June 19, 2017

RE: Letter of Intent
AT&T 75' Monopole and Antenna Relocation
13250 Ray Nixon Road, Fountain, CO 80817 – 45.07ac Parcel, Zoned A-5

NEW NORTHEAST
 ELEVATION

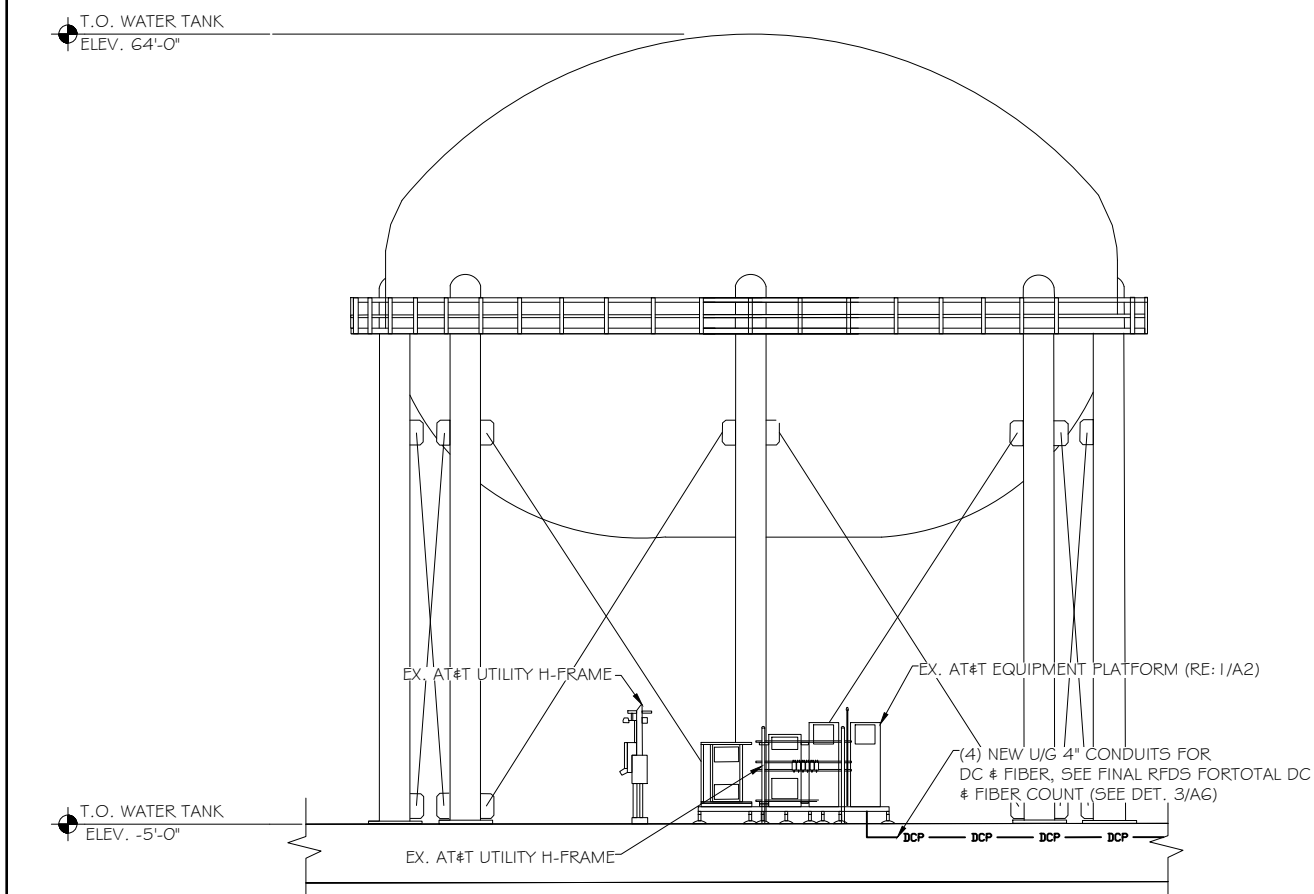
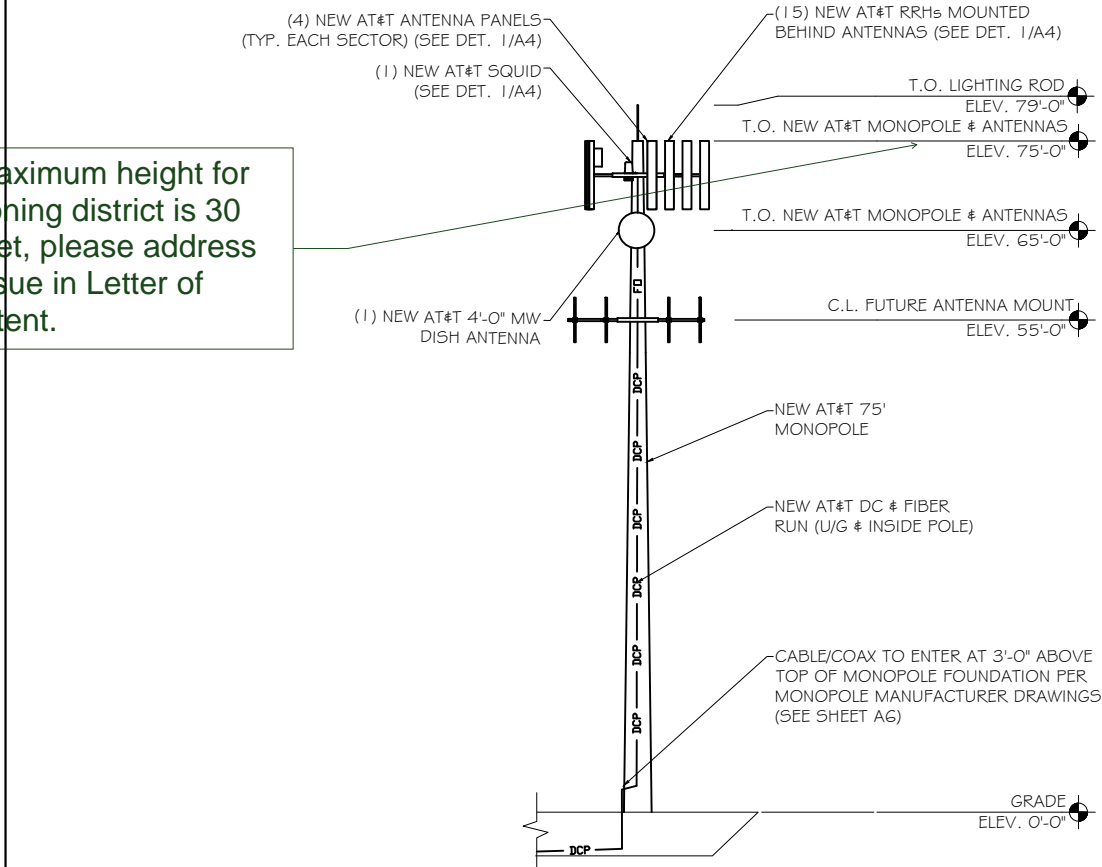
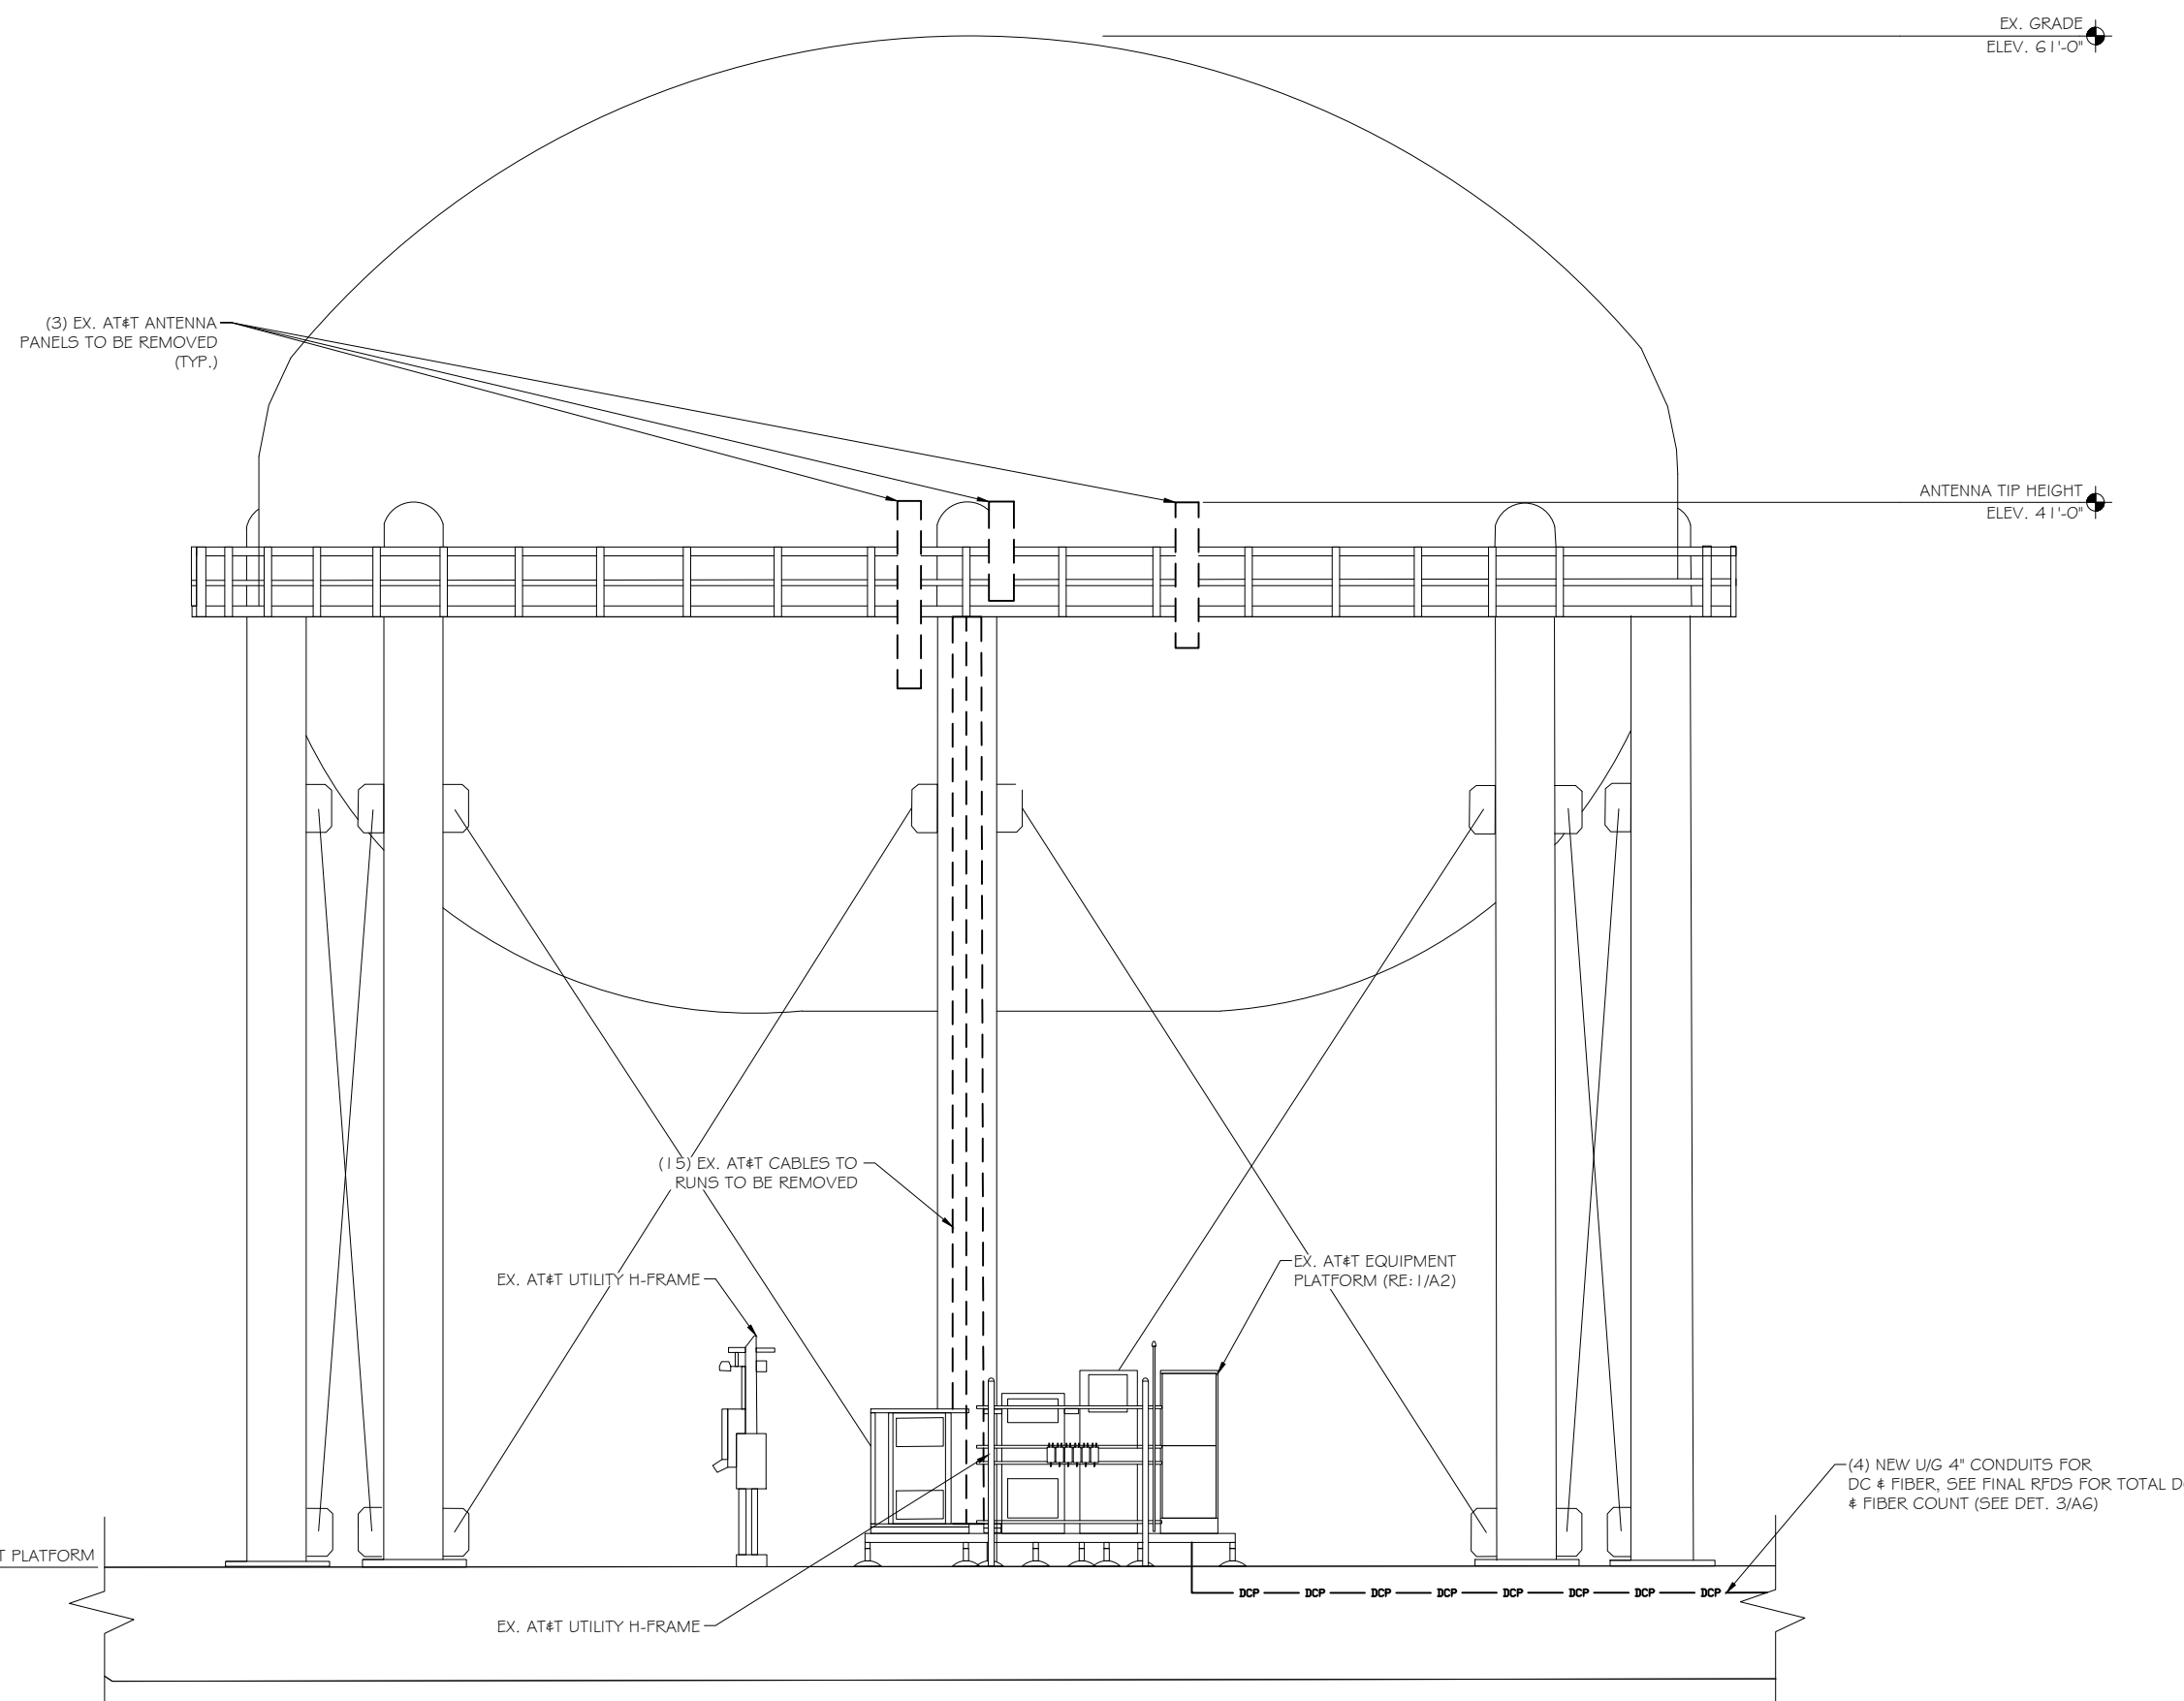
Maximum height for freestanding CMRS facilities shall not exceed the maximum structure height limit in the zoning district (A-5 is 30 feet) unless authorized as part of the use approval, your Letter of Intent needs to address and specifically ask for a variance to the height requirements to allow for a 75 foot monopole
